Freedom Forever
Planset Revision Letter

5/28/2024
REV #1

BRIAN SAMUELS
59 BARK WAY , ANGIER, NC 27501

ROOF MOUNT PHOTOVOLTAIC SYSTEM

SITE PLAN			
JOB NO:	DATE:	DESIGNED BY:	SHEET:
441414	5/23/2024	H.B.	PV-2

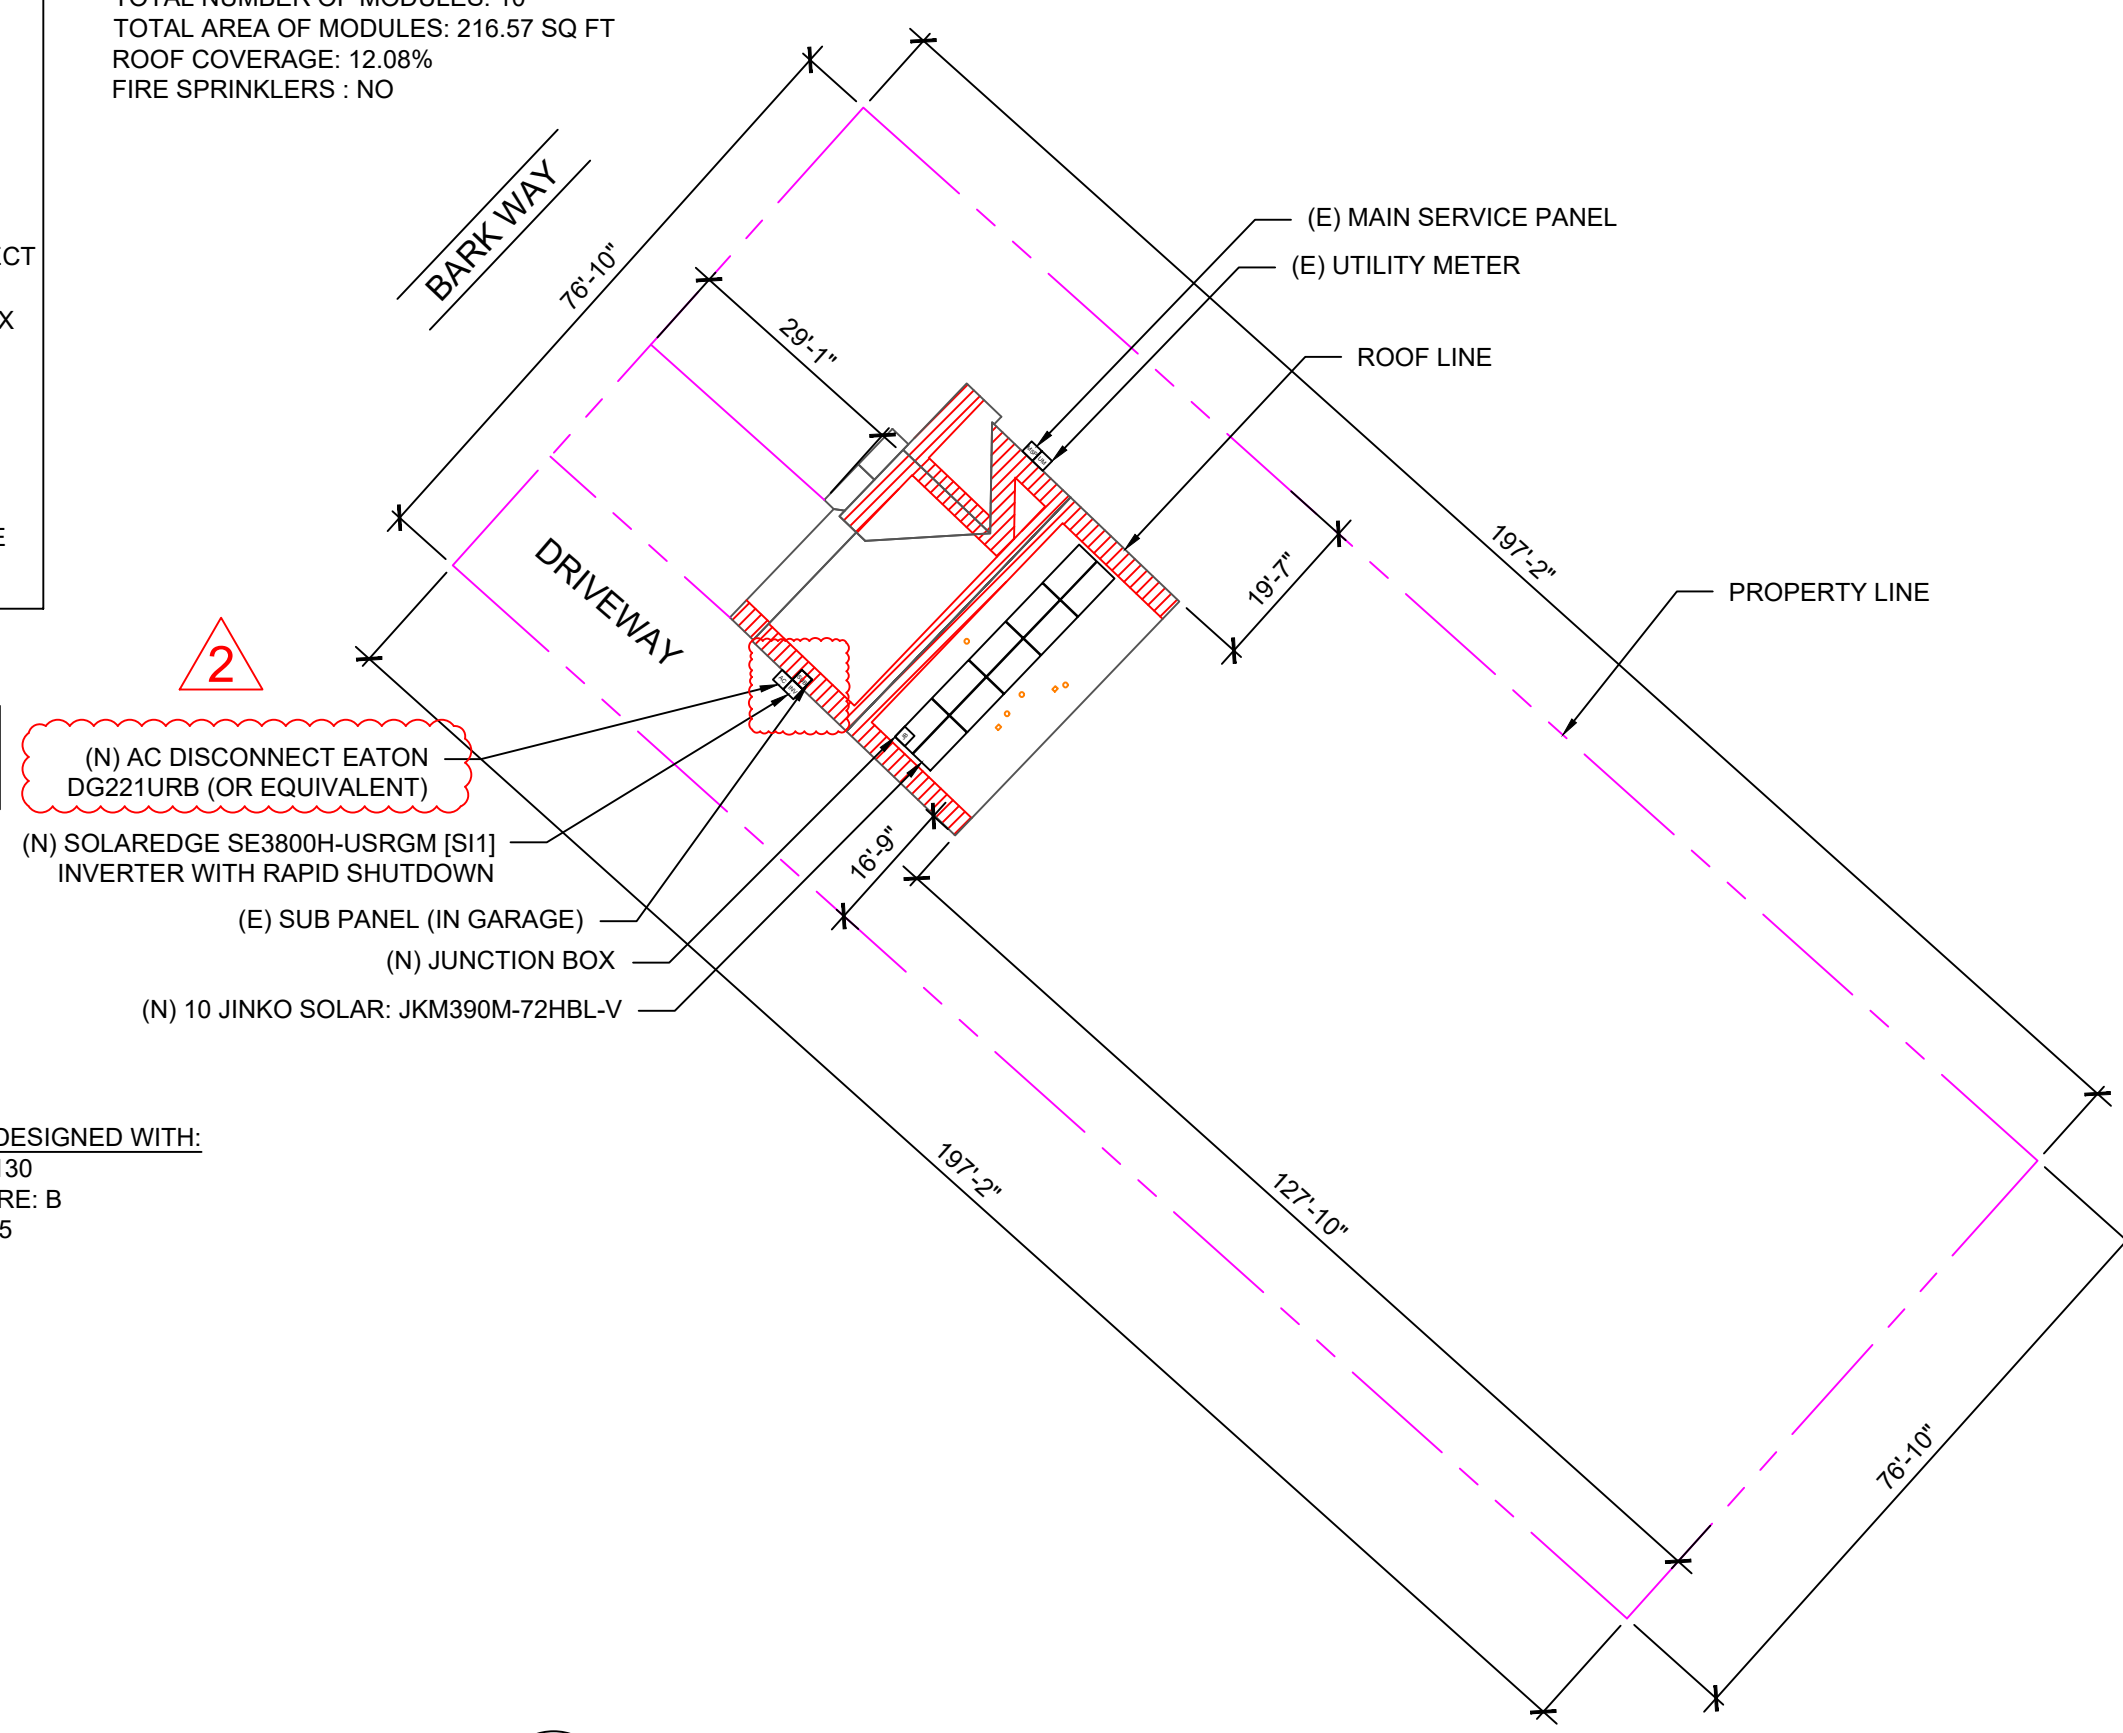
Inverter moved to the SW side of the home

All corresponding changes are notated on the plans by revision clouds.
